Consultation Response from KC, Highways Development Management (HDM)

2024/91242 Land north east of Shepley Road, Stocksmoor, Huddersfield, HD4 6XW

Erection of residential development (up to 50 dwellings) with associated access, parking, public open space, landscaping and infrastructure

Date Responded: 11/04/25 | Responding Officer: A.Darwin | Responding Ref: 12-33/18

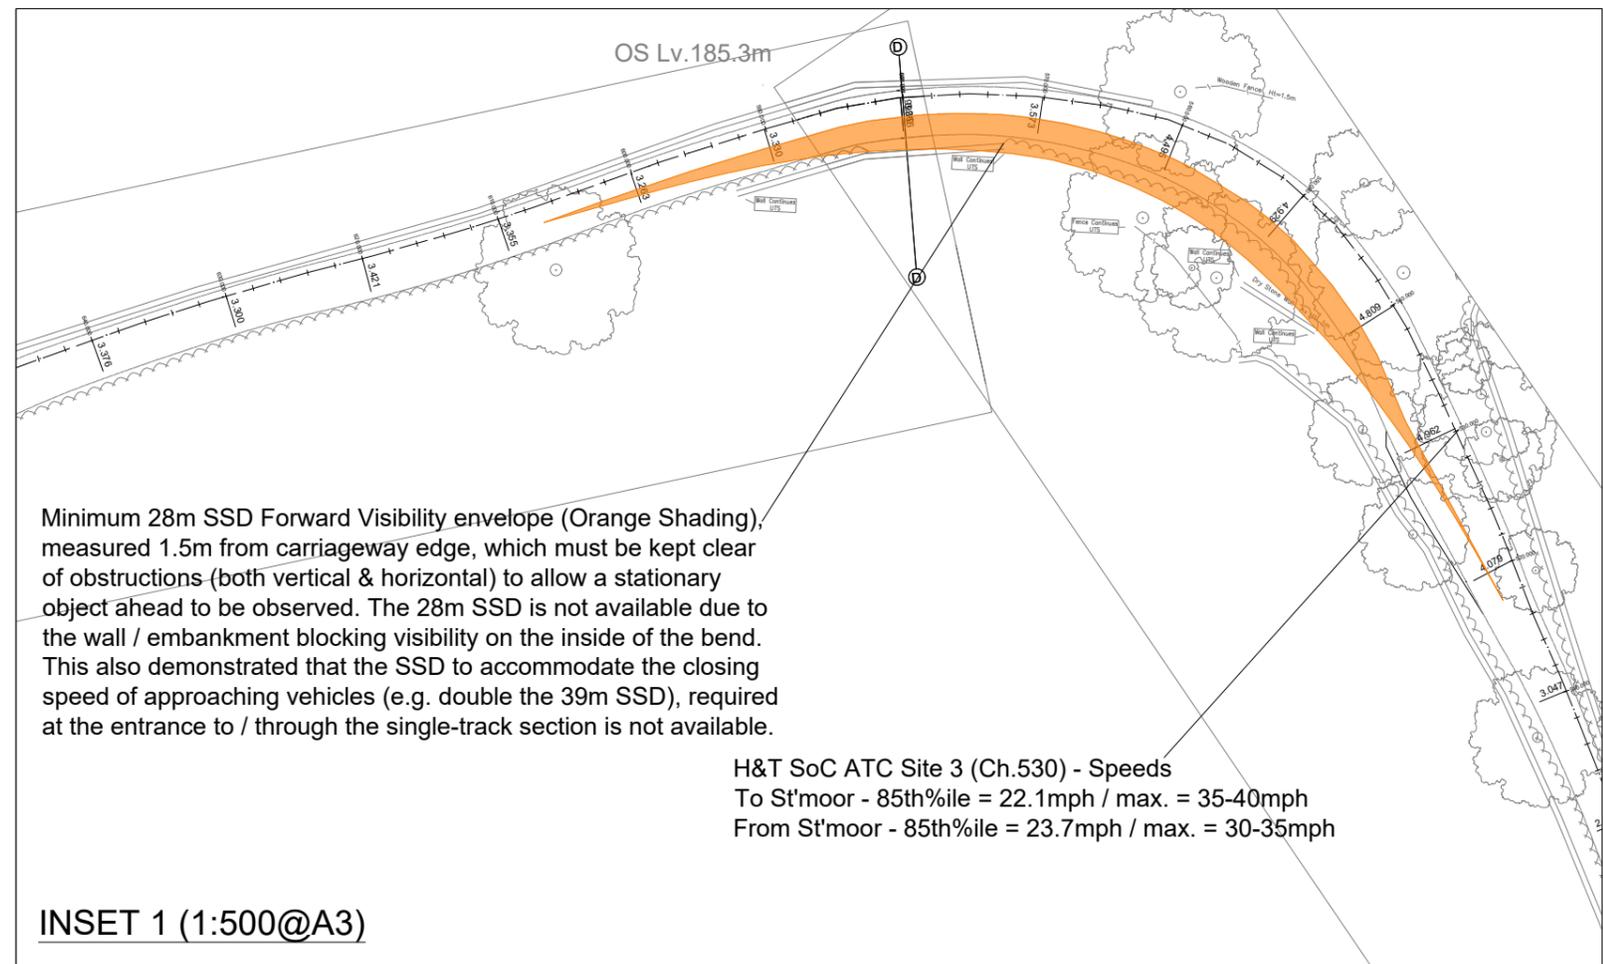
- Whilst some vegetation clearance has been noted on the plans, there are still a number of sections along the route where there would be inadequate inter-visibility between passing places, which cannot be improved due to the horizontal and vertical alignment of the highway, as well as vegetation and other features that are outside of the highway boundary that cannot readily altered.

- Even with the improvements, there would still be a number of sections of Stone Wood Lane where the spacing of passing places (for cars/vans) is well beyond the recommended maximum distance of 60m,

- A 140m+ length between ch.700-560, which also has restricted forward visibility due to bends and a steep gradient;
- A 60m+ length between ch. 520-460, which also has restricted visibility due to a bend and the vertical alignment of the carriageway;
- A 100m+ length between ch.440-340, which also has restricted forward visibility due to bends;
- A 70m length between ch.300-230, which also has restricted forward visibility due to bends;
- A 100m+ length between ch.120-20;
- For a 500m section of Stone Wood Lane between ch. 20 to 520, the carriageway width is generally between 2.6-3.5m wide (except at the passing places), which is below the width where a car/van can safely pass a pedestrian or cyclists, as acknowledged in the TAA report.
